Appeal Decision

Appeal Ref: APP/R5510/W/24/3354486

28 Station Approach, South Ruislip, Ruislip, Hillingdon HA4 6RY

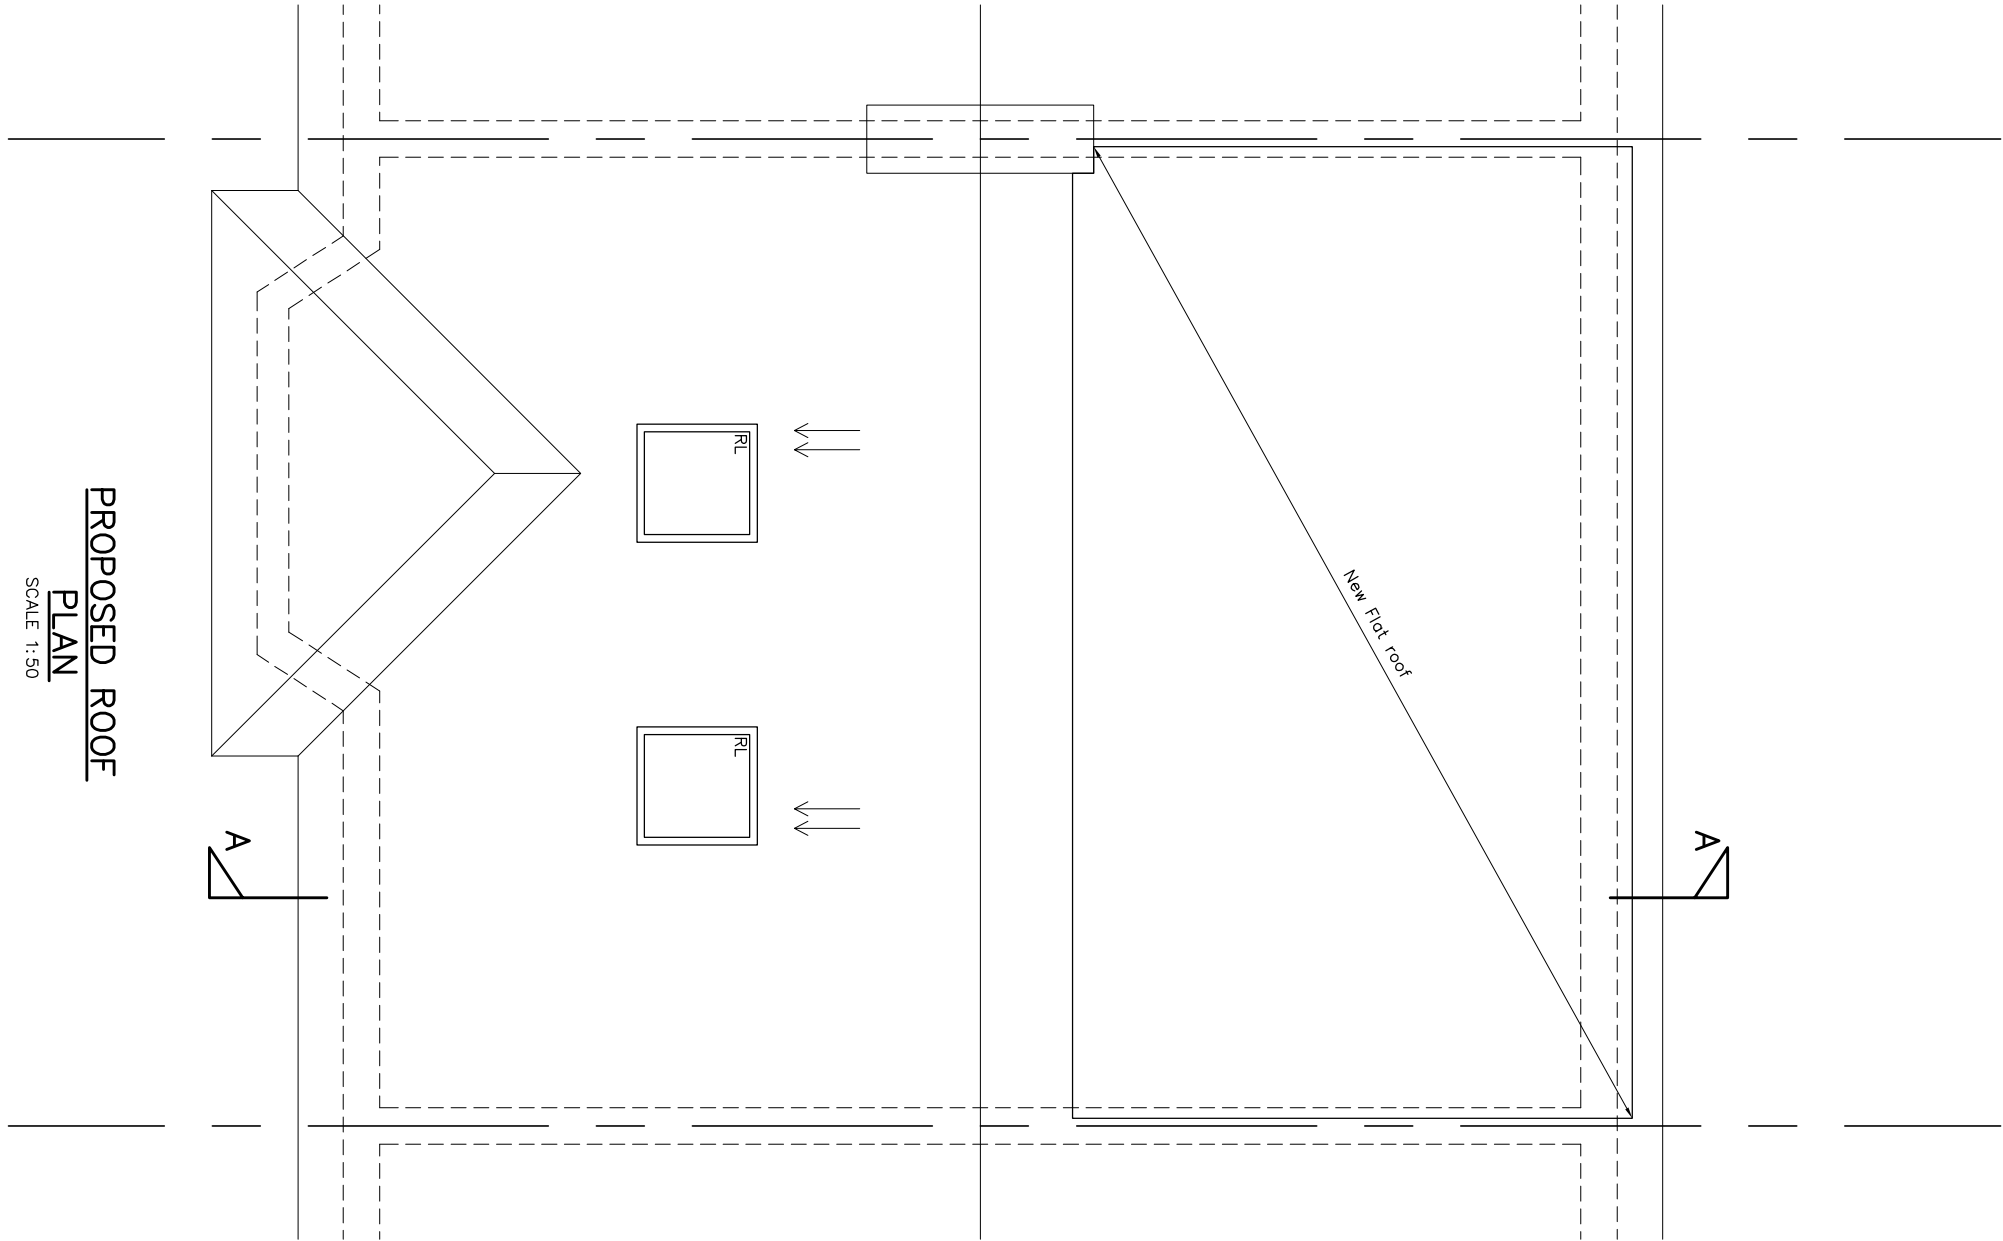
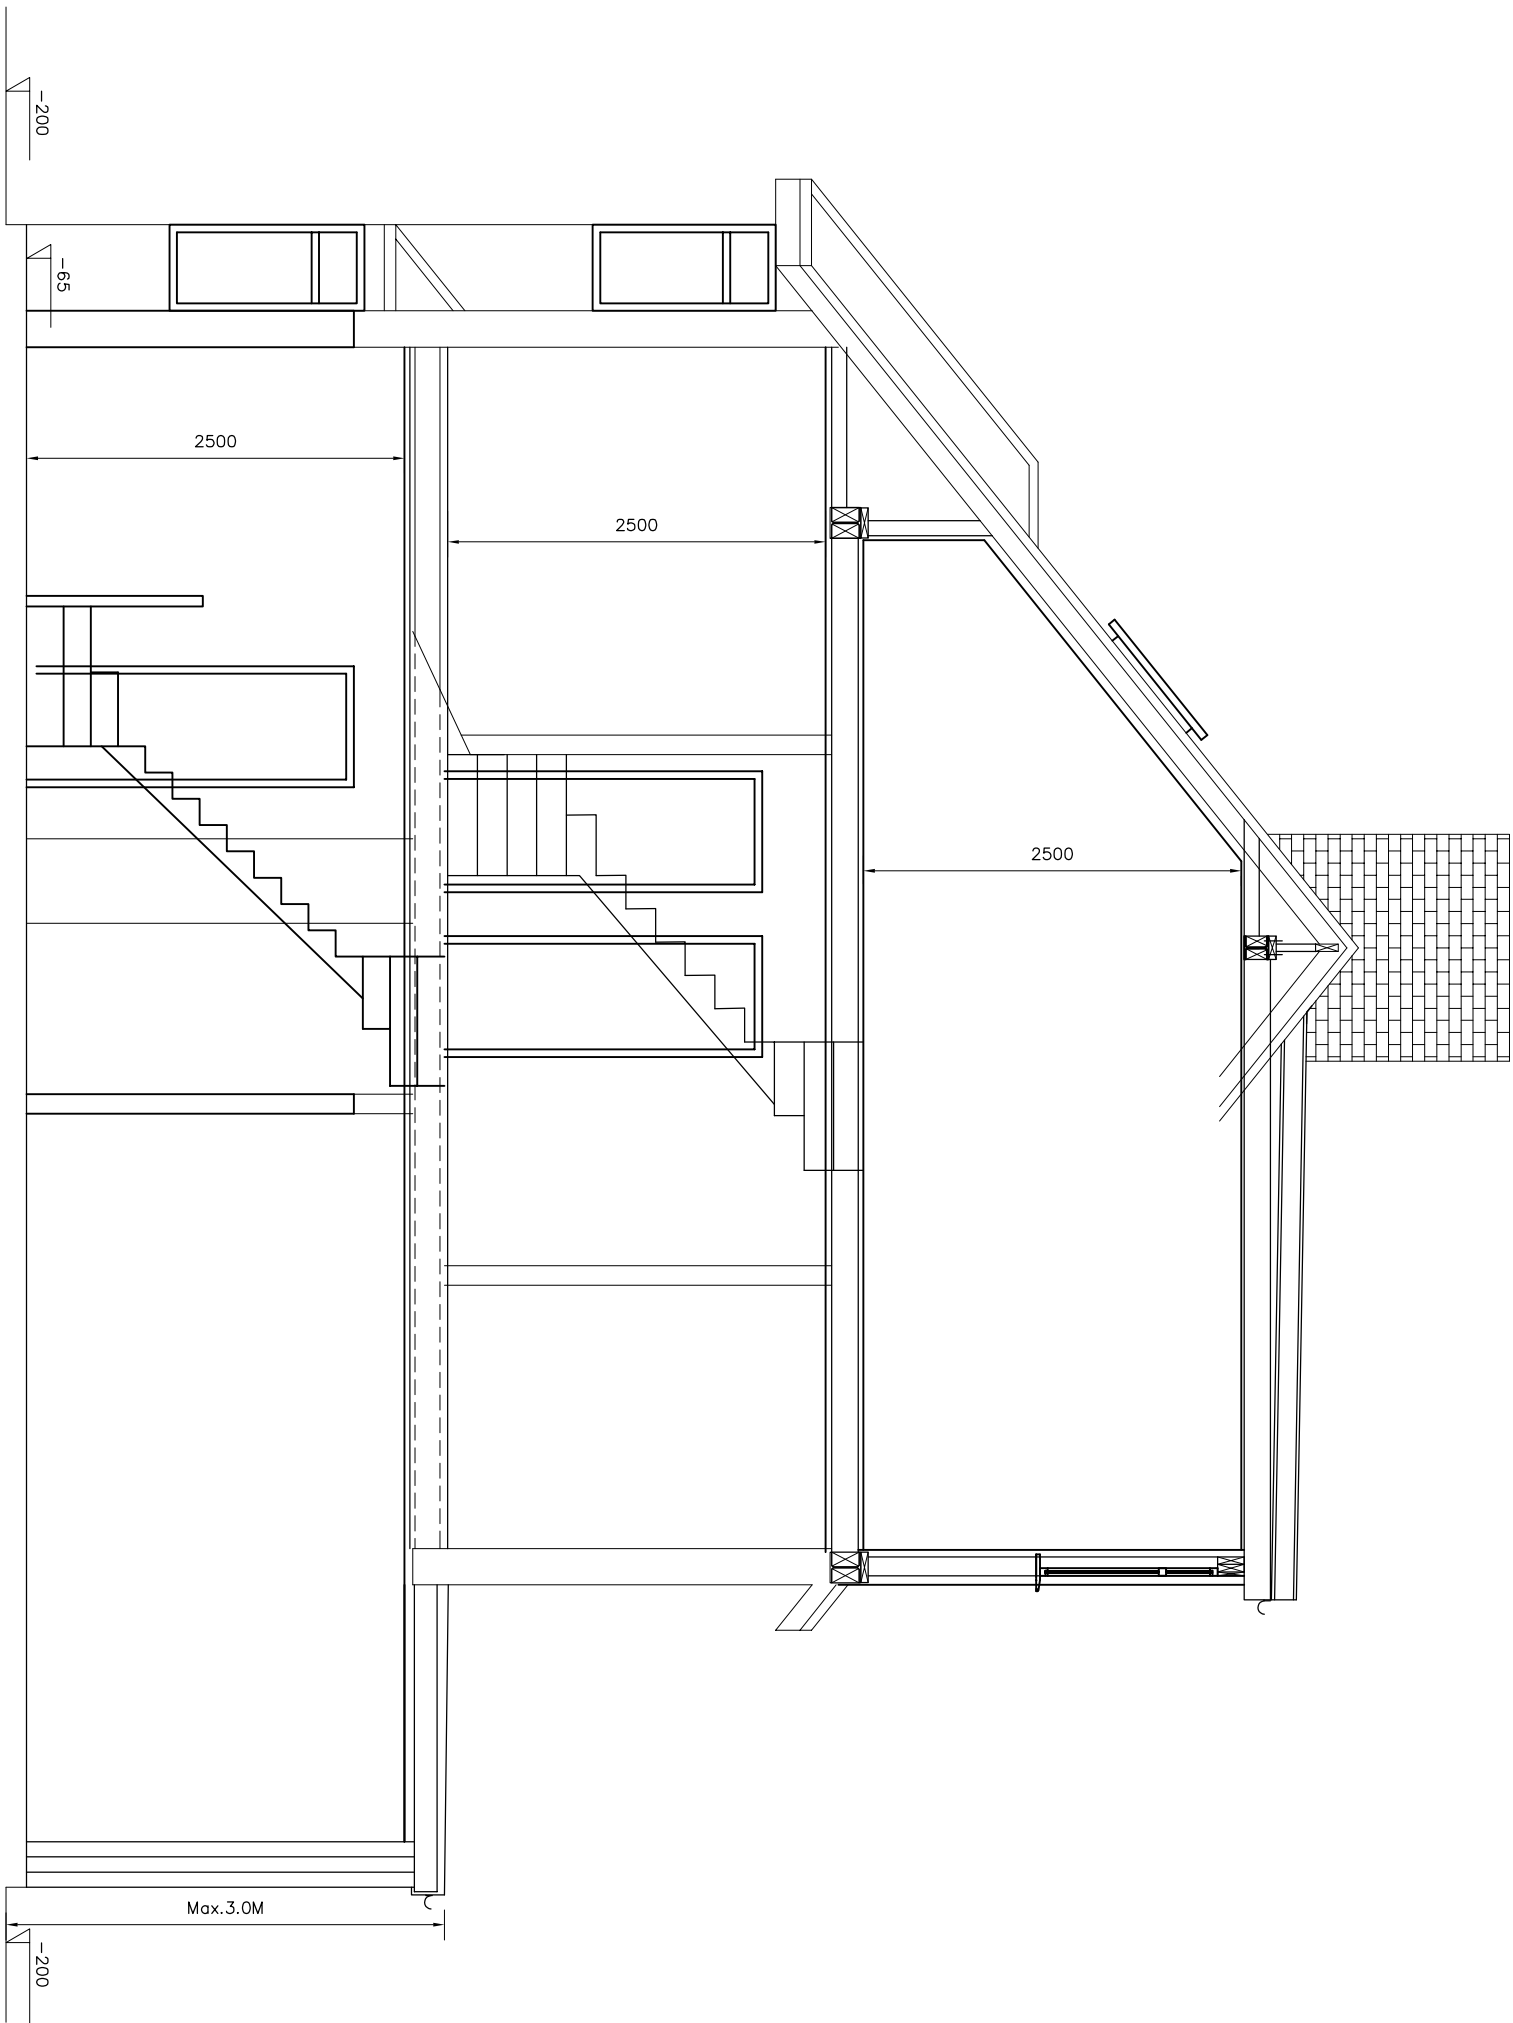
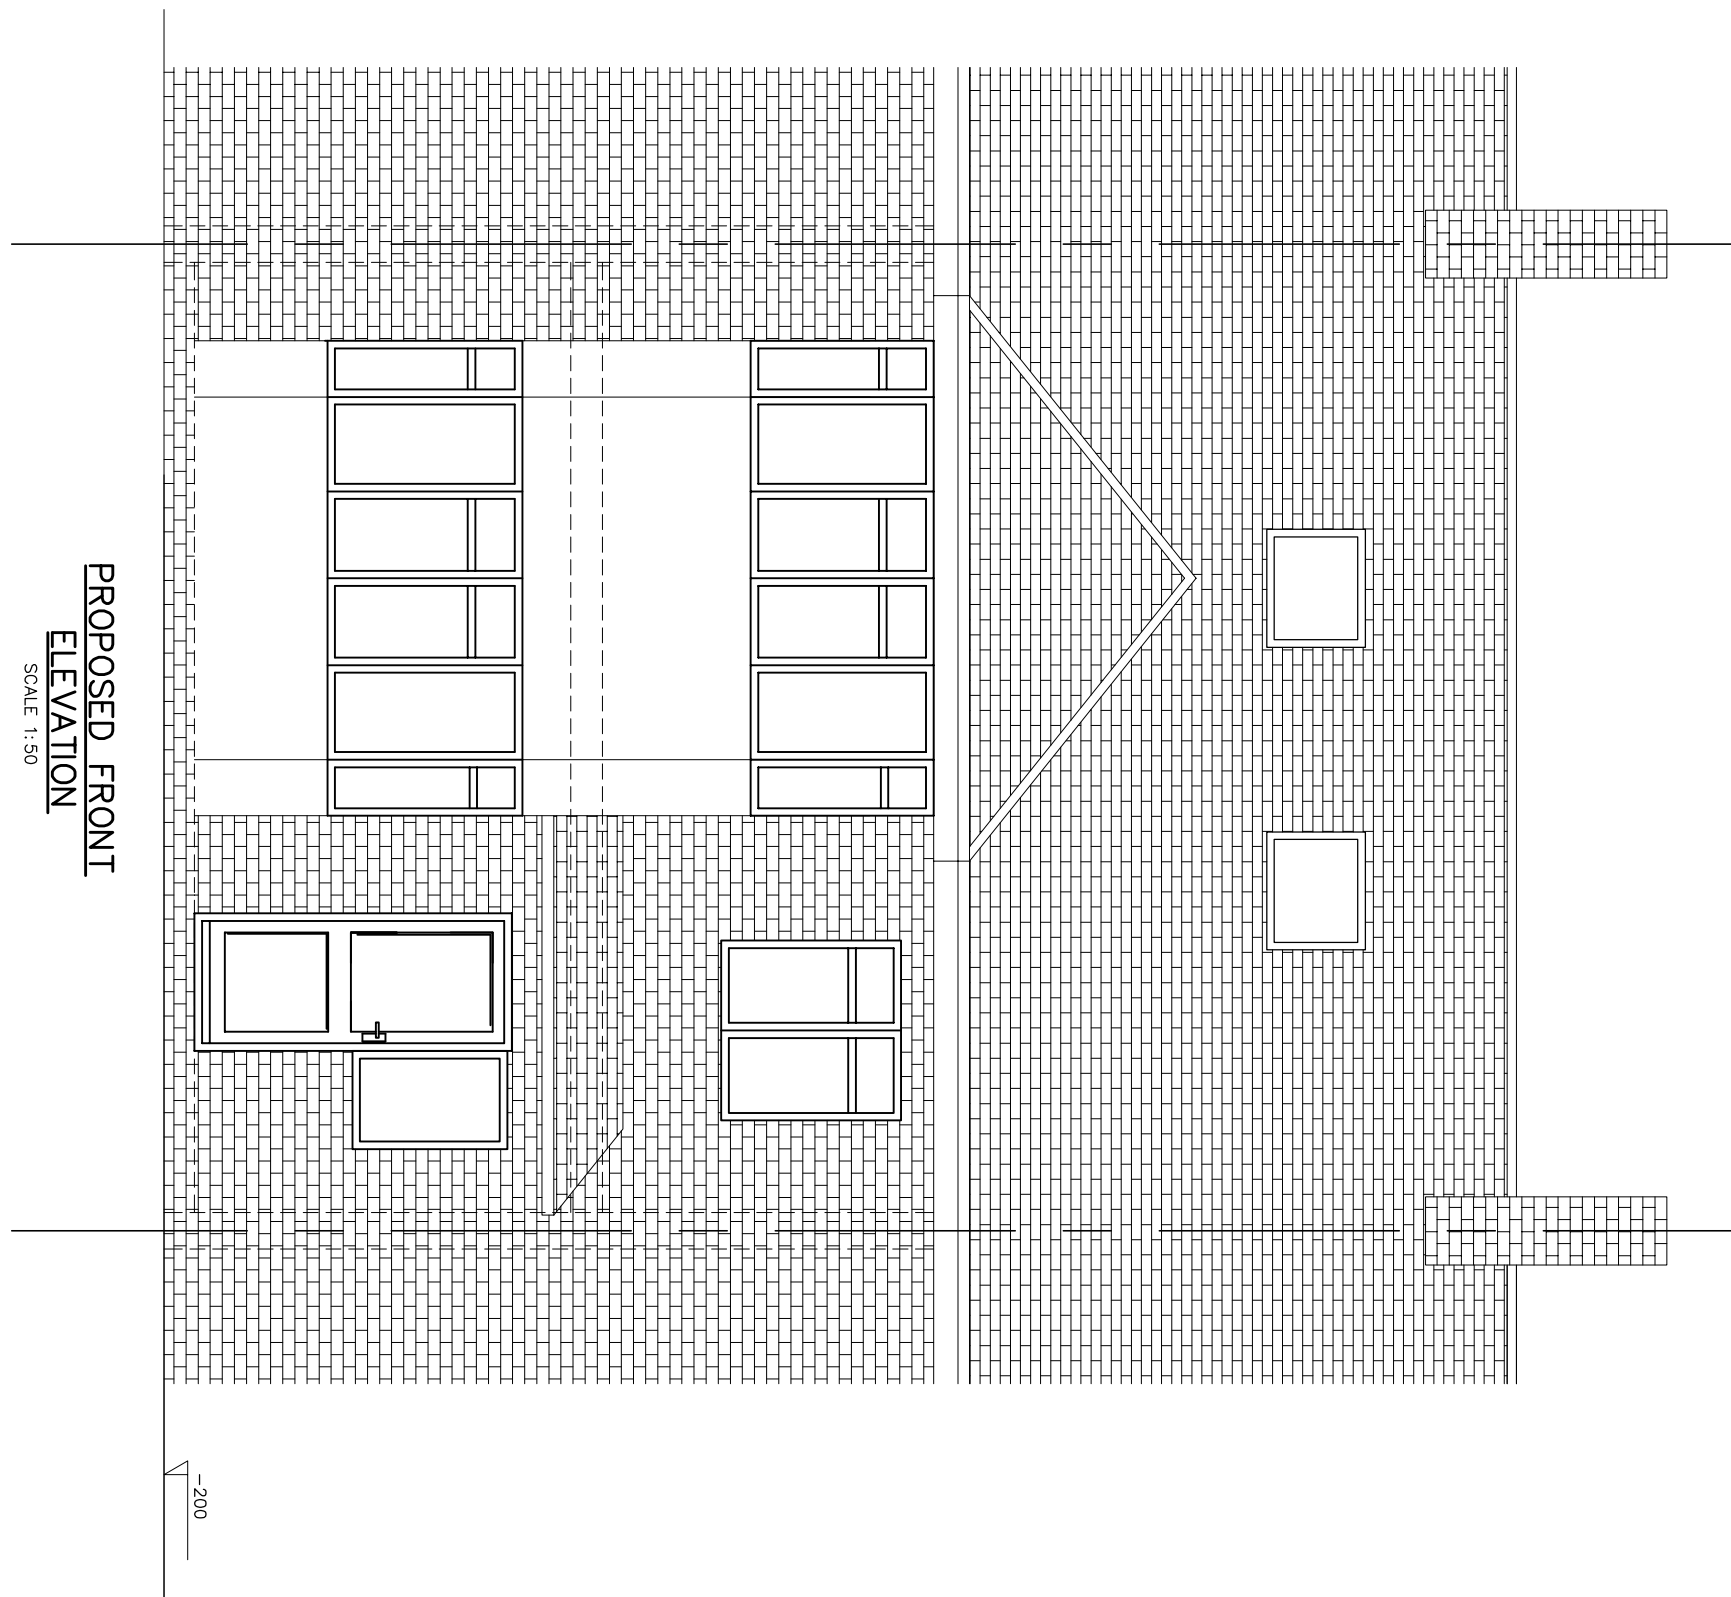
13. The appeal scheme does not provide any outdoor private amenity space for the two-bedroom flat.
14. The appeal site is within walking distance of the green opposite and Stonefield Park. However, I note that these green spaces are public and as such would not serve the same function as private outdoor amenity space and would be insufficient to make up for the deficit of outdoor space at the appeal site.

18. The flat situated on the ground floor would have its single bedroom situated at the front of the property, adjacent to the shared front door and with outlook through a bay window directly into the proposed shared parking area.

19. Future occupiers of the bedroom would be subject to noise and disturbance associated with the movement of vehicles, such as engine noise and light from the headlights. Users of the parking area would also have direct views into the bedroom. Due to the proximity of the bedroom to the parking area, I find that this would result in a highly intrusive relationship in relation to noise, disturbance and overlooking from users of the parking area which would be detrimental to the living conditions of future occupiers of this flat.

20. The appellant has suggested mitigation measures, including soft landscaping, obscure glazing on the side panel of the bay window and planting. They also suggest that parking for the ground floor flat could be allocated in front of the bedroom window and that the level of parking could be reduced in order to increase the amount of landscaping and therefore buffer between the bedroom window and parking spaces. However, I do not have convincing evidence before me which demonstrates any of these measures would fully mitigate my concerns, particularly in relation to noise and disturbance from vehicles.

25. The Council has confirmed in its evidence, the LP requirement would equate to approximately two spaces for the two flats proposed. I also note this is the position of the Highway Authority which has suggested reducing the quantum of spaces to two in their consultation response to the planning application.

26. The appellant has suggested that, notwithstanding the details shown on the proposed plans, they would be willing to reduce the number of spaces down to two, facilitated by soft landscaping to reduce the hardstanding and would be secured by a condition.

27. In the event that I was minded to allow the appeal, I am satisfied an appropriately worded condition could be imposed to secure two parking spaces which would be appropriate provision in this location. As such, subject to such a condition, the proposal would comply with Policy T6.1 of the LP.
